Phone: 
Email: 
Your ref: 3/2026/0094-0095
Our ref: 3_2026_0094-0095-LCC
Date: 13th March 2026

Planning and Listed Building Applications 3/2026/0094 and 0095: Proposed conversion of 2no. curtilage listed barns (Main Barn/Barn 2) to create 2no. dwellings and the re-building of a smaller stone barn (Barn 3) for ancillary use (re-built for safety/practicality).

Barns at Winkley Hall Farm, Whalley Road, Hurst Green BB7 9PN

drawing number Ex 3

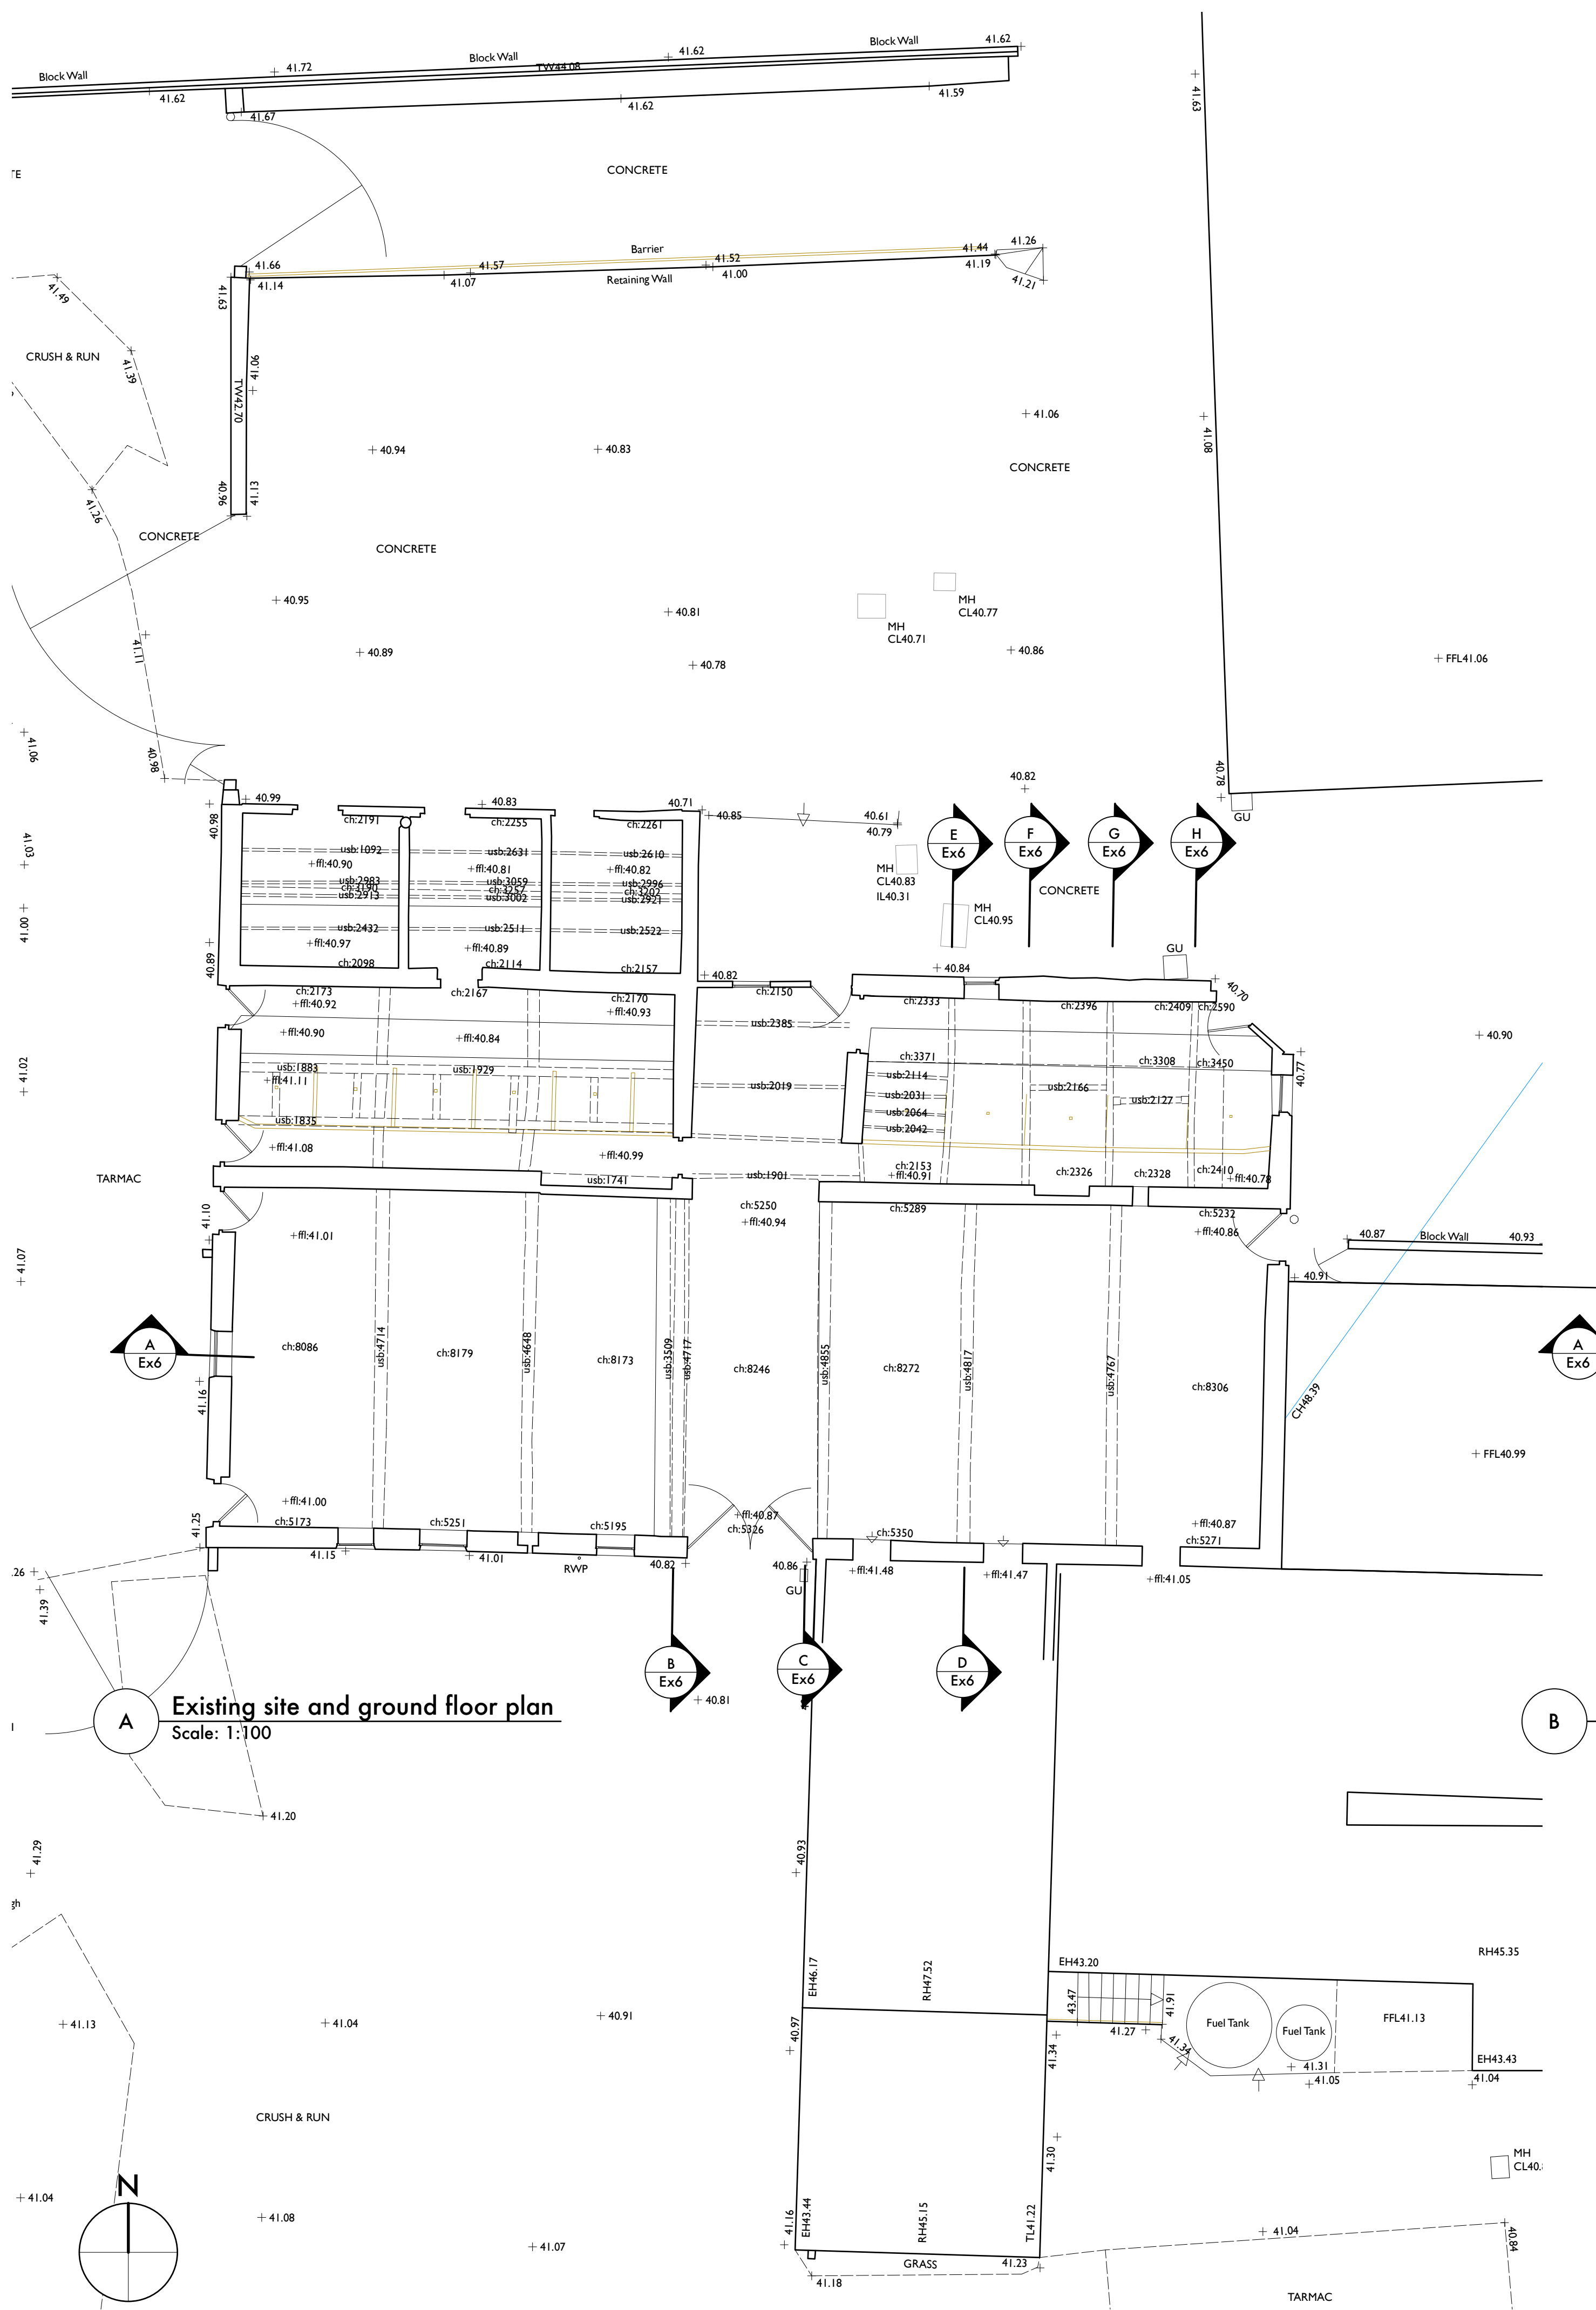
It should be particularly noted that the 'plans as existing' provided with the application are inaccurate in respect of the part walled and part timber aisle post division between the main space and northern aisle in the main barn noted above, nor are the aisle posts shown in the 'plans as proposed'. These omissions will need to be addressed, and appropriate details submitted including at least one long section of the main barn and two cross sections (both 'as existing' and 'as proposed') should be provided, showing the existing structures and how they are impacted by the proposals. For barn 2 it is also not clear how the proposed changes to the upper floors will impact the extant roof structure and again at least one long section and a cross section (as existing and as proposed) showing the roof structure should be submitted. This needs to be done prior to a decision being reached, so that the council and its conservation advisors will be sure of what alterations are being proposed and how these will impact the historic roof structures and the main barn aisle posts.

As well as the amended drawings noted above, more details need to be provided setting out how the repairs and alterations are to be undertaken and their extent, showing that this will be achieved without the removal of the (possibly unique) aisle posts or of significant amounts of the structural timberwork of the roofs, and without excessive demolition and rebuilding of the stonework. The method statement for these works should include a commitment to retaining as much of the structural timberwork as is possible, with repairs and reinforcement being undertaken rather than replacement. Details of any new foundation works and floor slabs will be necessary, along with details of roof surface repairs, internal and external woodwork, drainage, rainwater goods, etc. The council and their conservation advisors may wish to see some or all these details prior to considering their decision, or by the application of suitable conditions on any consents.

A North Facing Section
Scale: 1:100

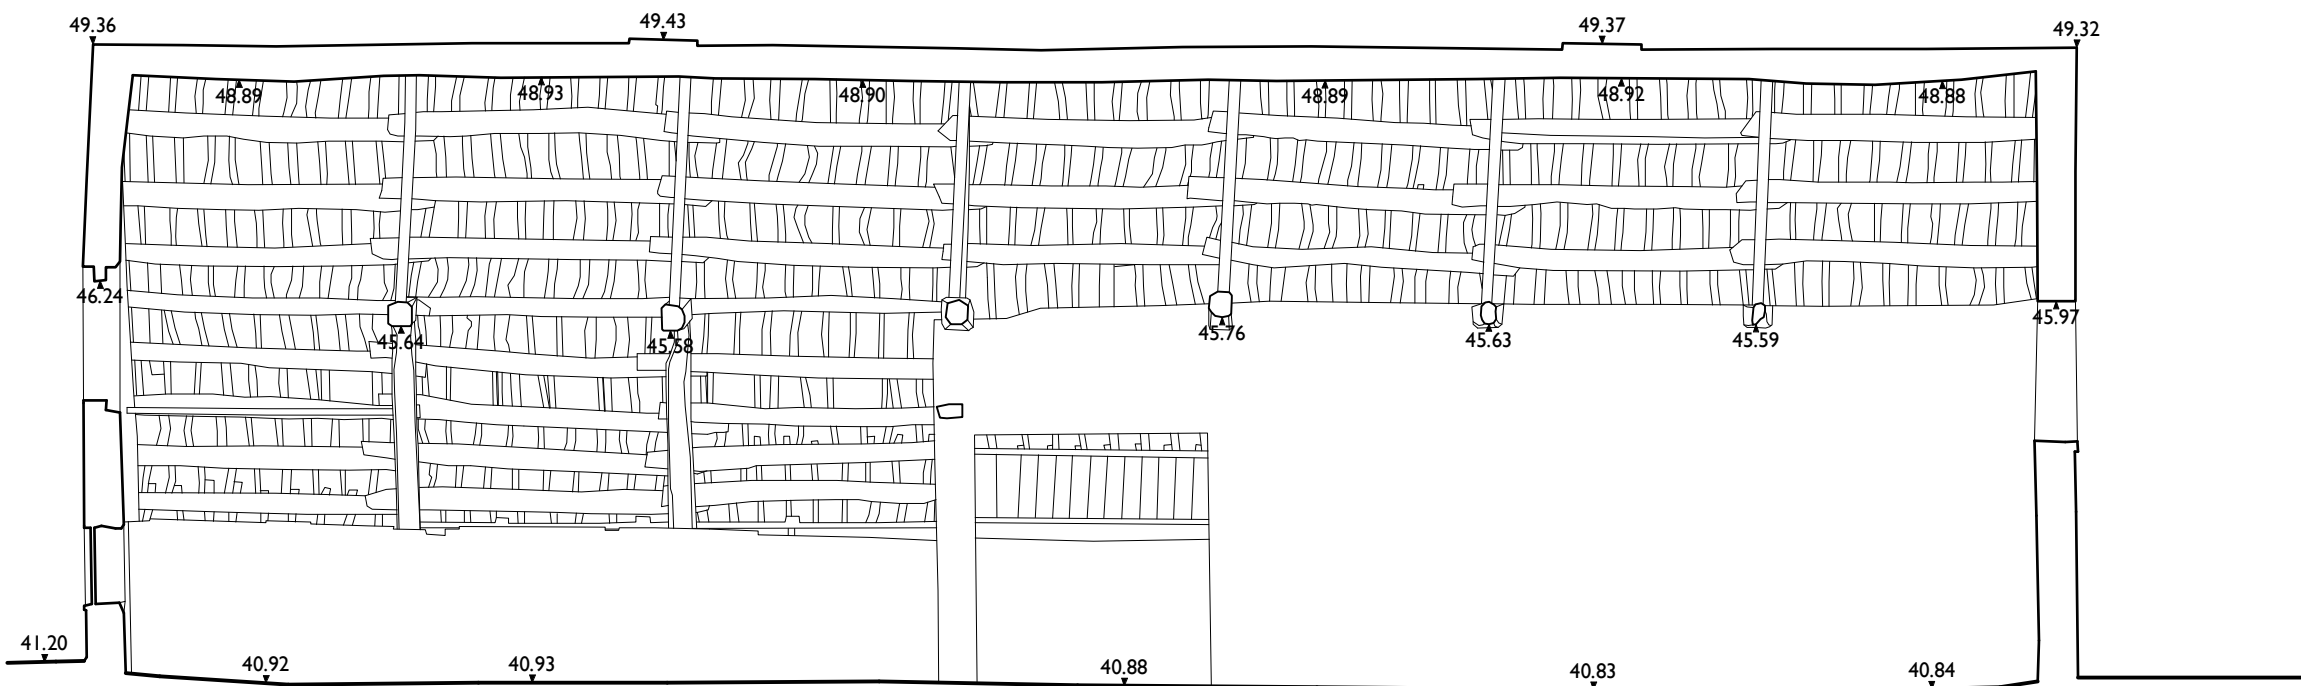
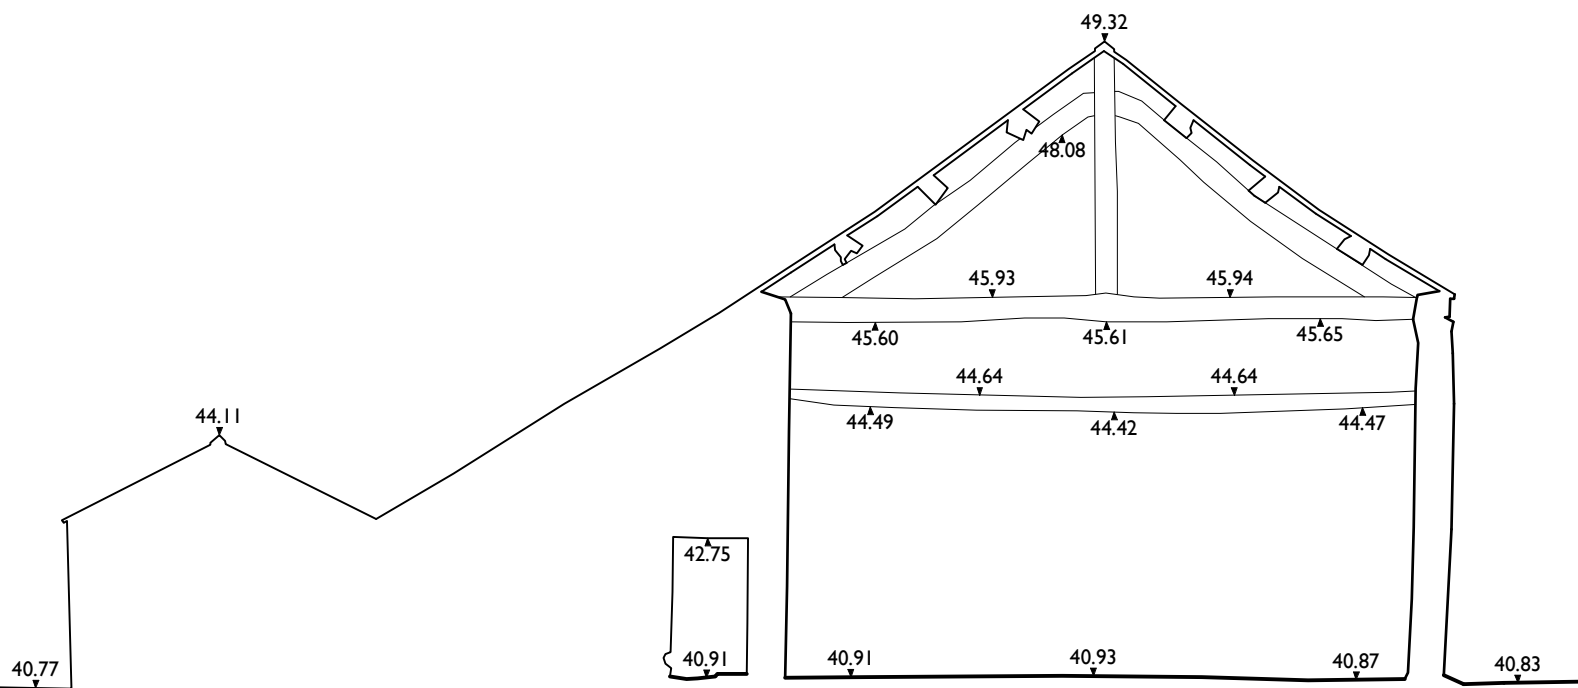
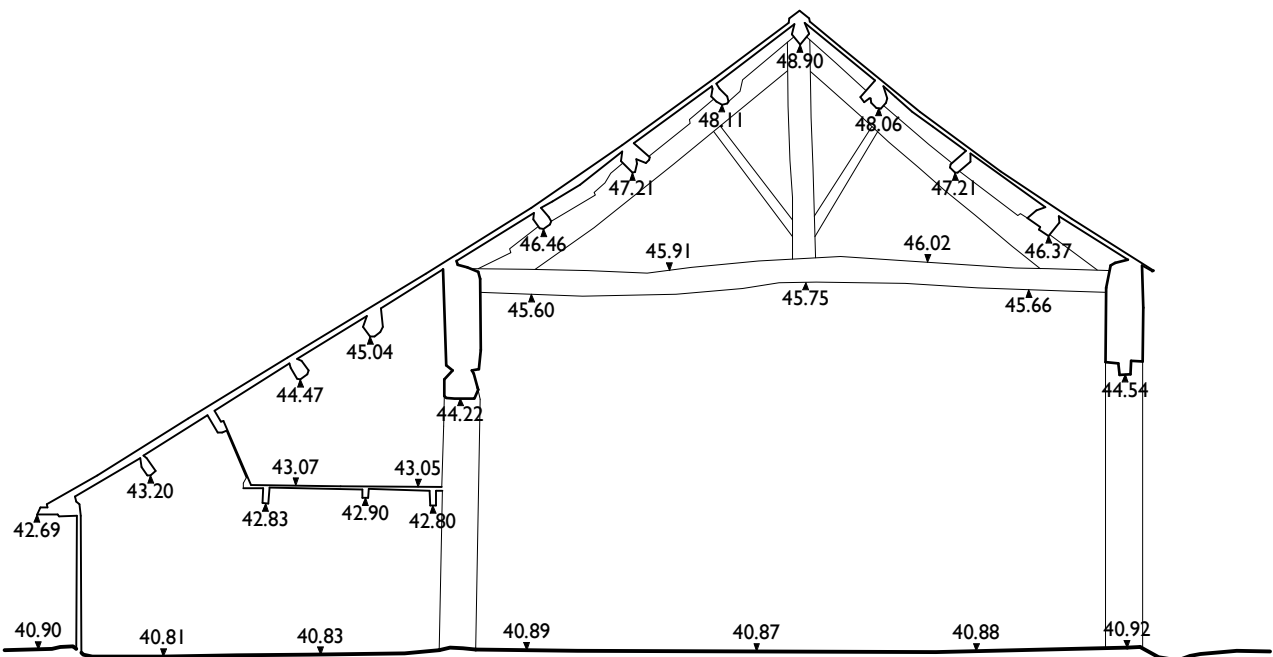
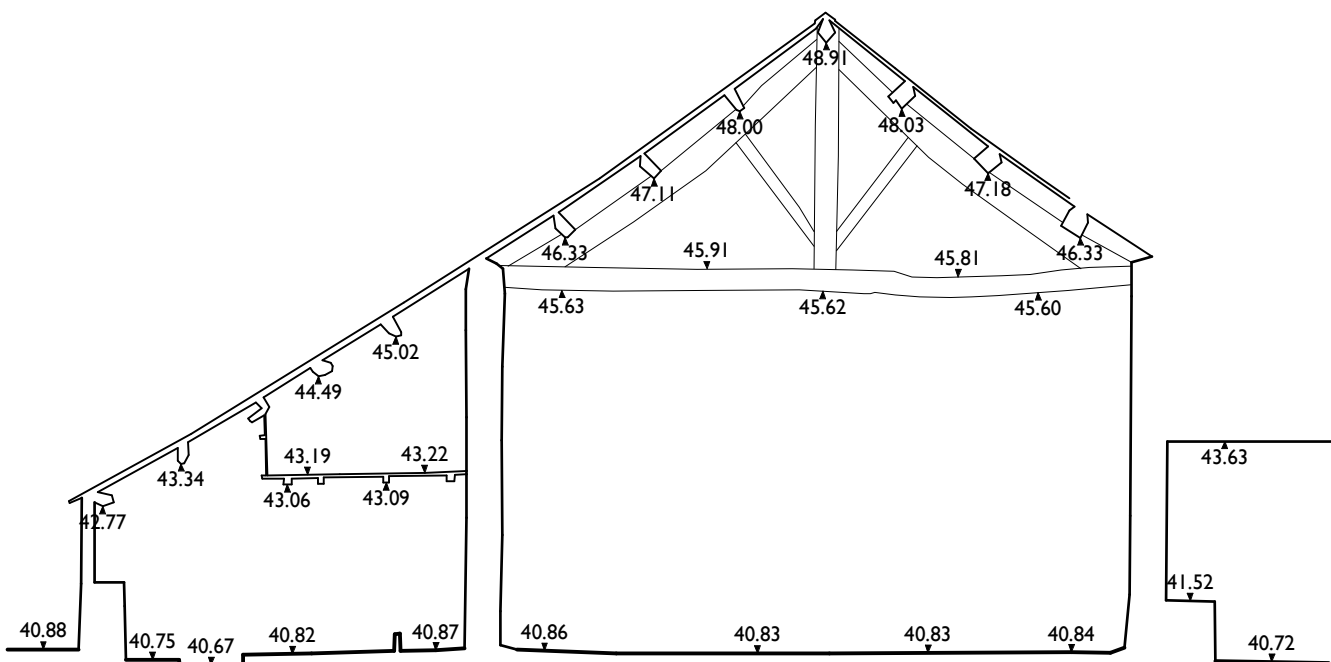
We would also stress that whilst we appreciate that the 'insect decay' and 'rot' noted in the SS report needs to be further investigated by an appropriate specialist with experience of working on heritage buildings, the timbers must be fully recorded (below) before any de-frassing or other destructive investigation or treatment is undertaken. De-frassing in particular is damaging to historic woodwork and is often structurally unnecessary (as in dry conditions insects generally only attack former sapwood leaving very solid heart timber). It is likely to remove important features such as evidence of how the timbers were cut, as well as historic graffiti and 'assembly marks' on the roof timbers, such as the engraved 'III' seen on the queen post and tie beam in SS photo 25.
